# Rezoning Transportation Analysis

Petition Number: 2022-116

## Revision Log:

# RZ-2

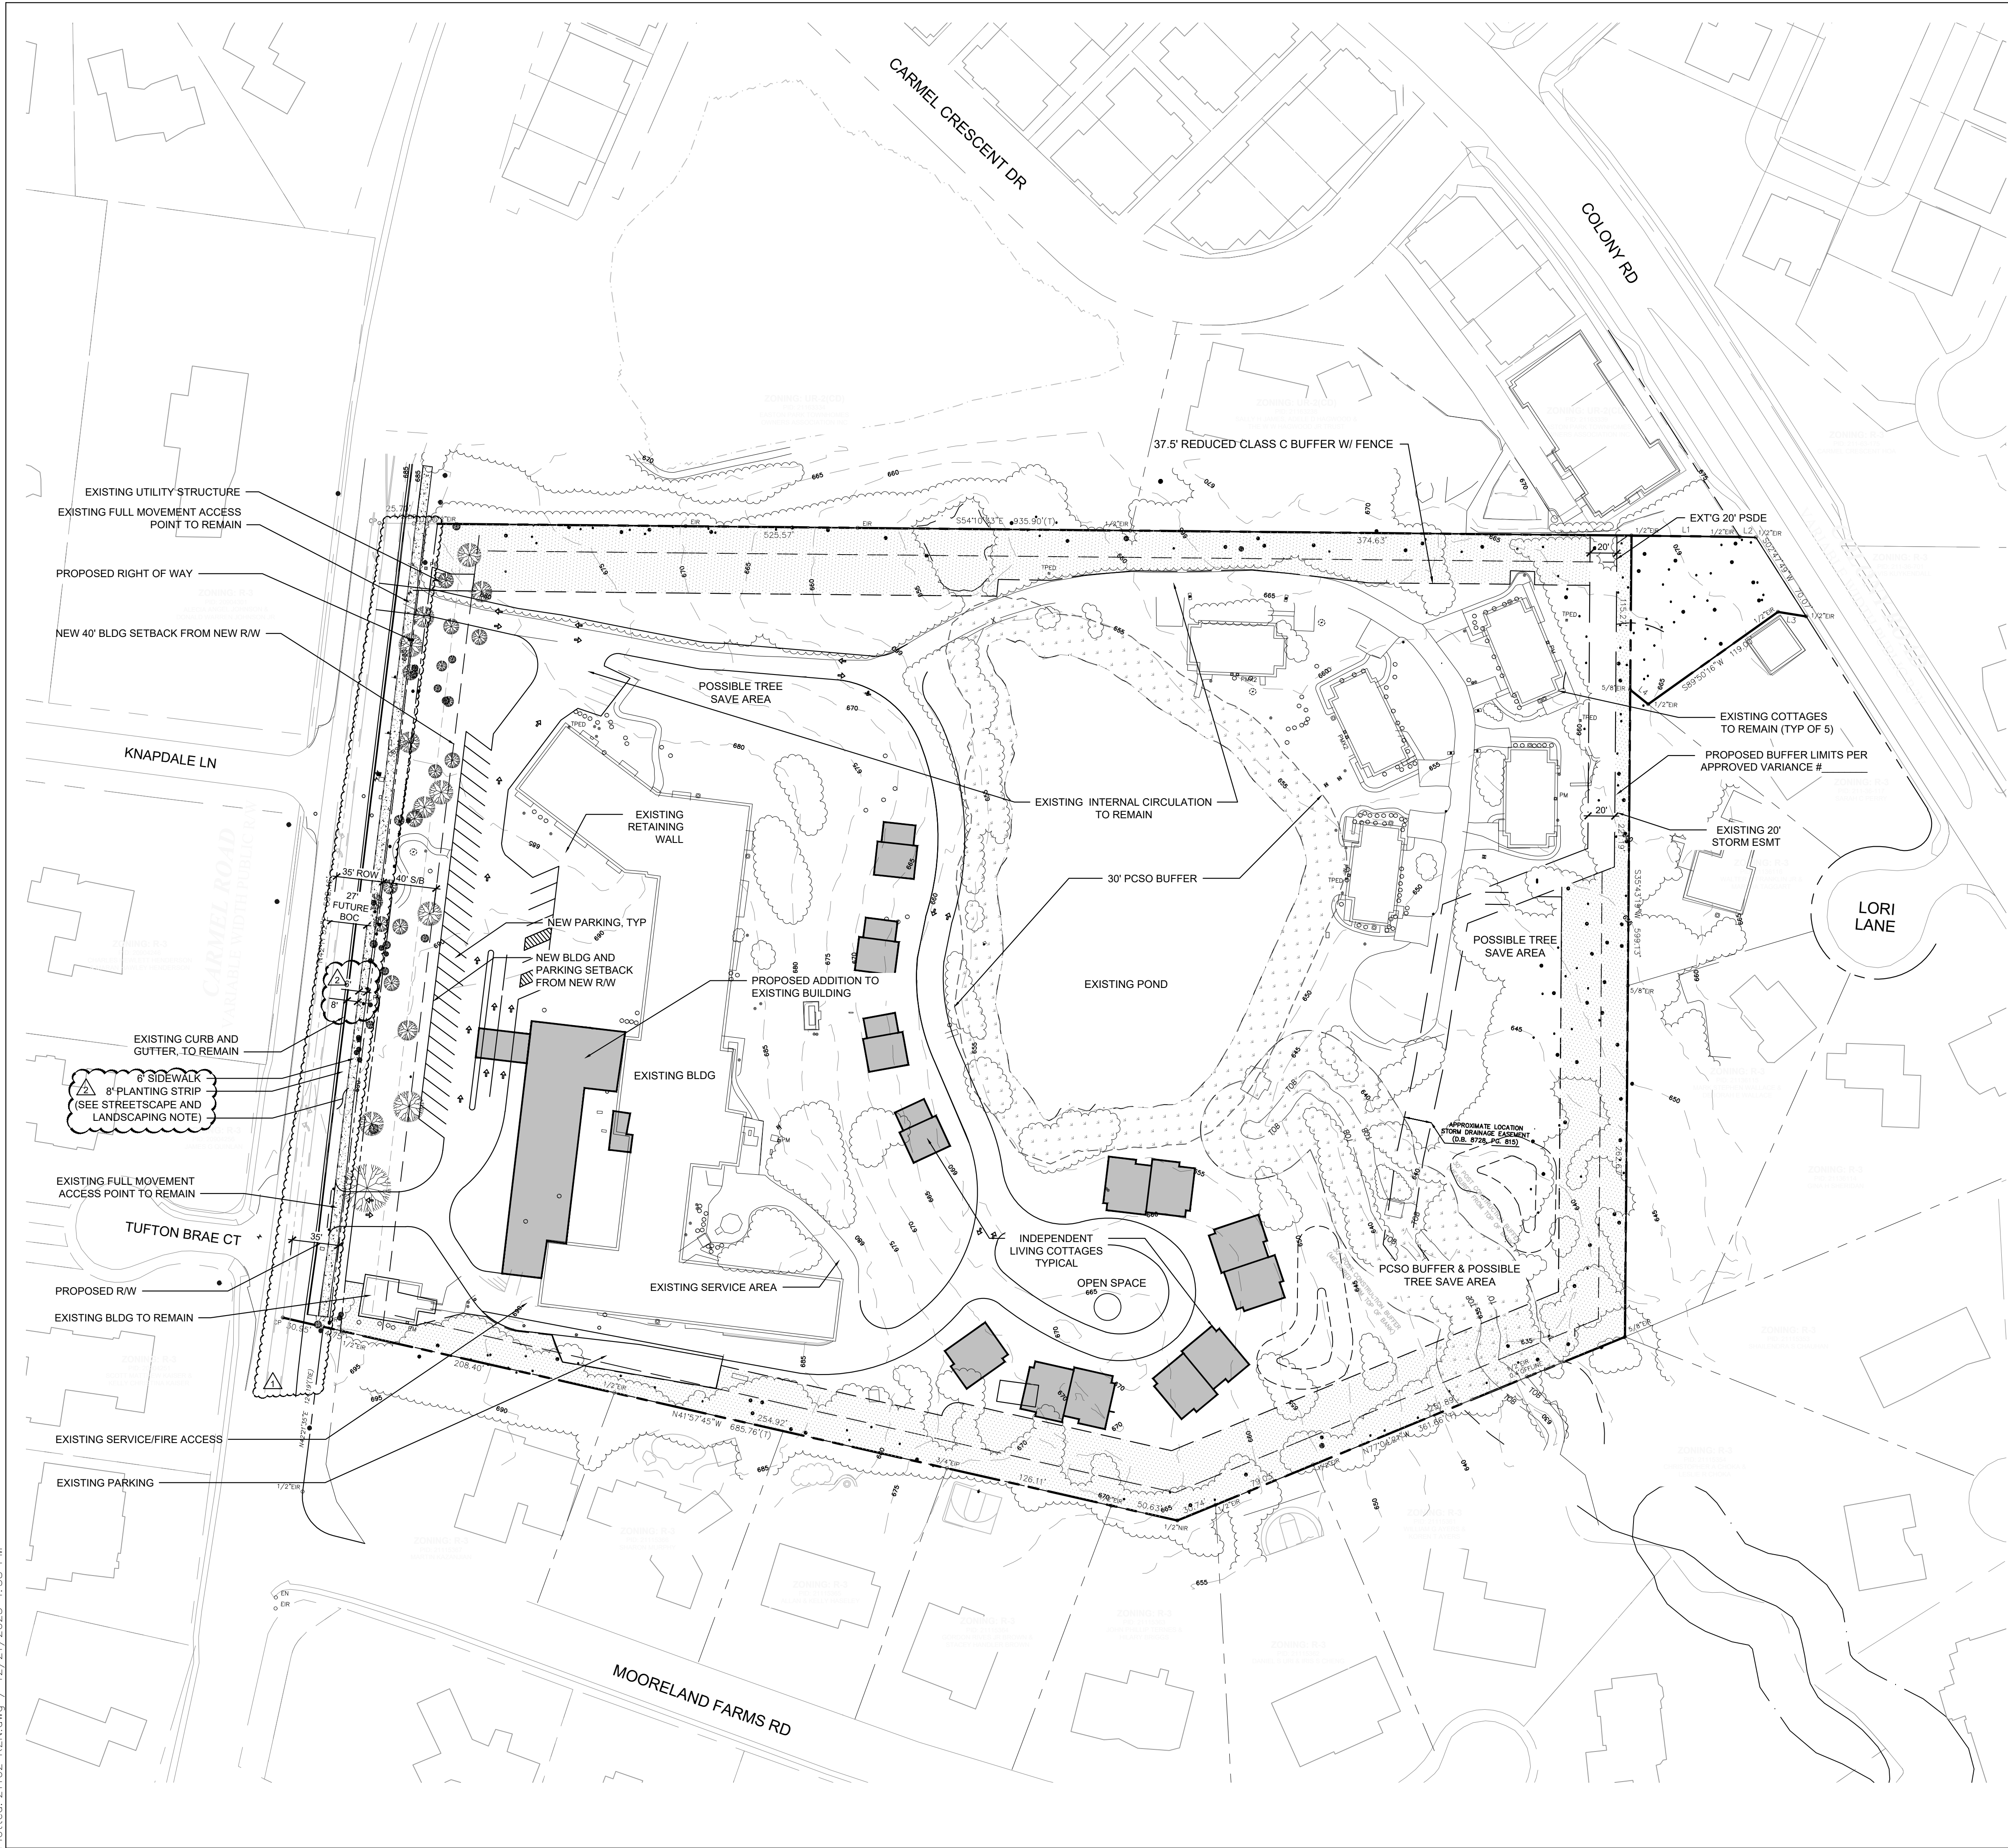
**Additional Comment 11/27/23** – Carmel Road needs to be labeled and include that it's a public road.

Per Chapter 19 revise site plan and conditional note(s) to commit to construct an 8-foot planting strip, and 6-foot sidewalk on Carmel Road.

**Clarifying Comment 11/27/23** – According to Chapter 19, there needs to be an 8-foot planting strip instead of the sidewalk located at the BOC as shown along Carmel Road and Colony Road.

**Clarifying Comment 12/28/23** – Commit to installation of 8' planting strip and 6' sidewalk in conditional notes.
